From: Laura Gibbons
Sent: 26 April 2019 09:51
To: Planning.Responses
Cc: Daniel Vick
Subject: RE: Planning Consultation on AL/36/19/DOC

Engineers Comments Regarding Condition 4- surface water drainage

NOTIFICATION FROM ARUN DISTRICT COUNCIL
TOWN AND COUNTRY PLANNING ACT 1990
APPLICATION AL/36/19/DOC

Description of Works: Approval of details reserved by condition imposed under ref AL 123/18/PL relating to Condition No 4 surface water drainage.

SKOL
PROPOSED S.I. WORKS
TP/CH LOCATIONS

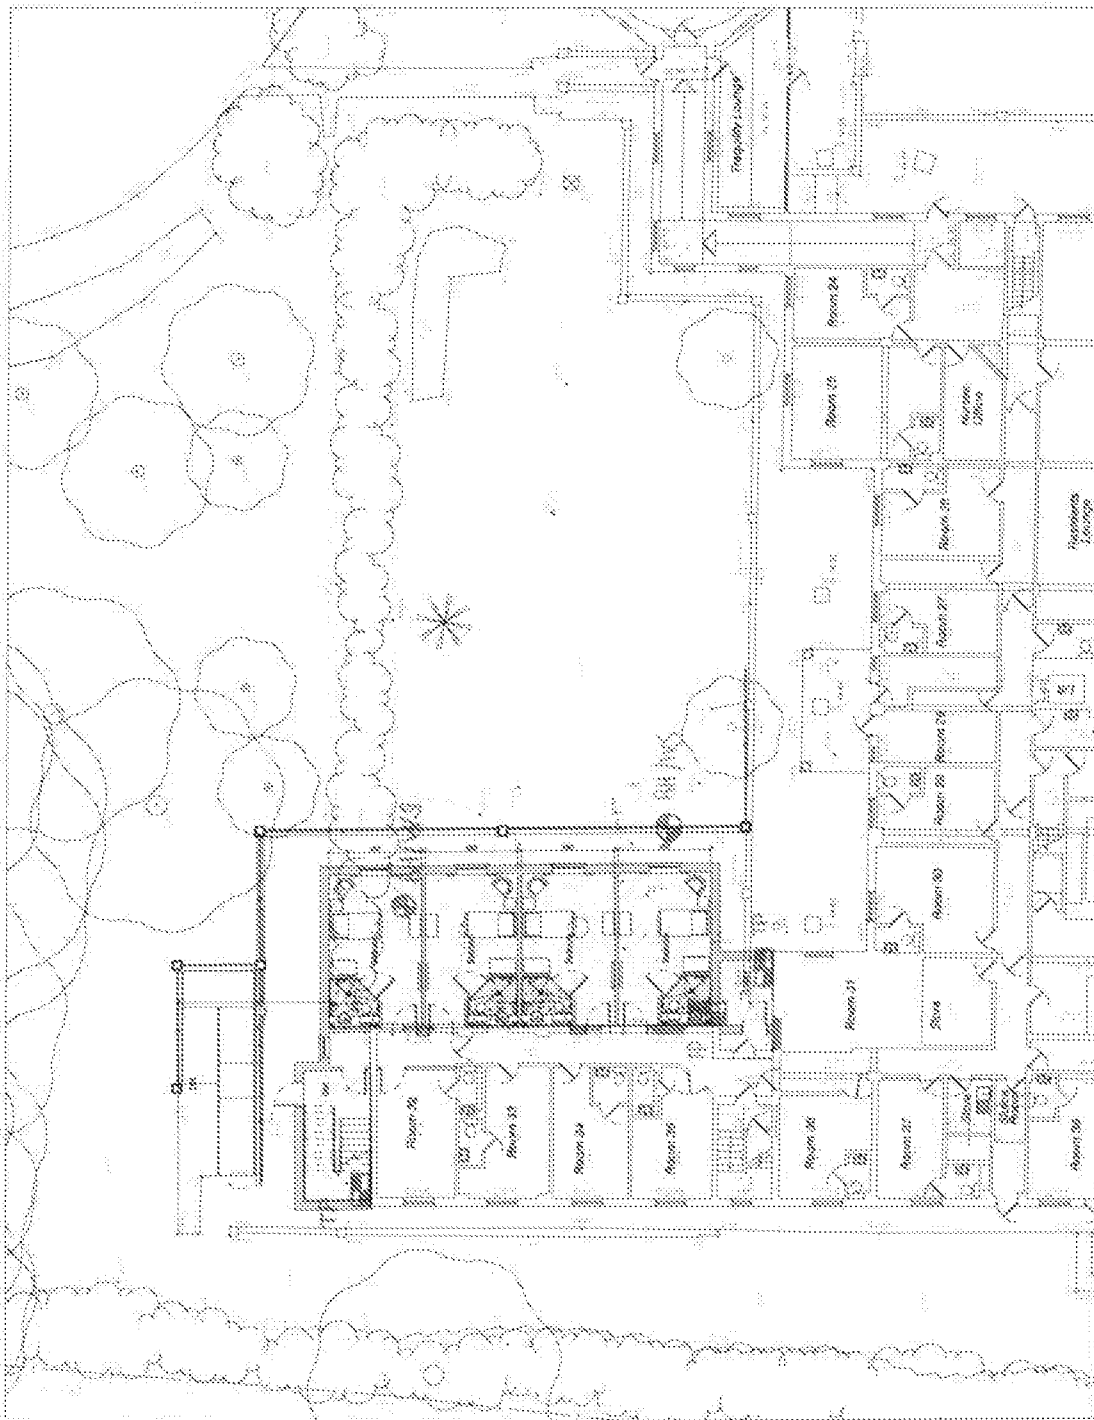
1. Please can a layout plan be provided which shows the location of the trial holes and groundwater monitoring points. The map provided does not include hole numbers.
2. The layout plan will need to be updated to include invert and cover levels of the soakaway.
3. Construction detail drawings need to show 100mm coarse sand bed and surround, and permeable geotextile.
4. Please provide construction detail drawings of pipe bedding and surround.
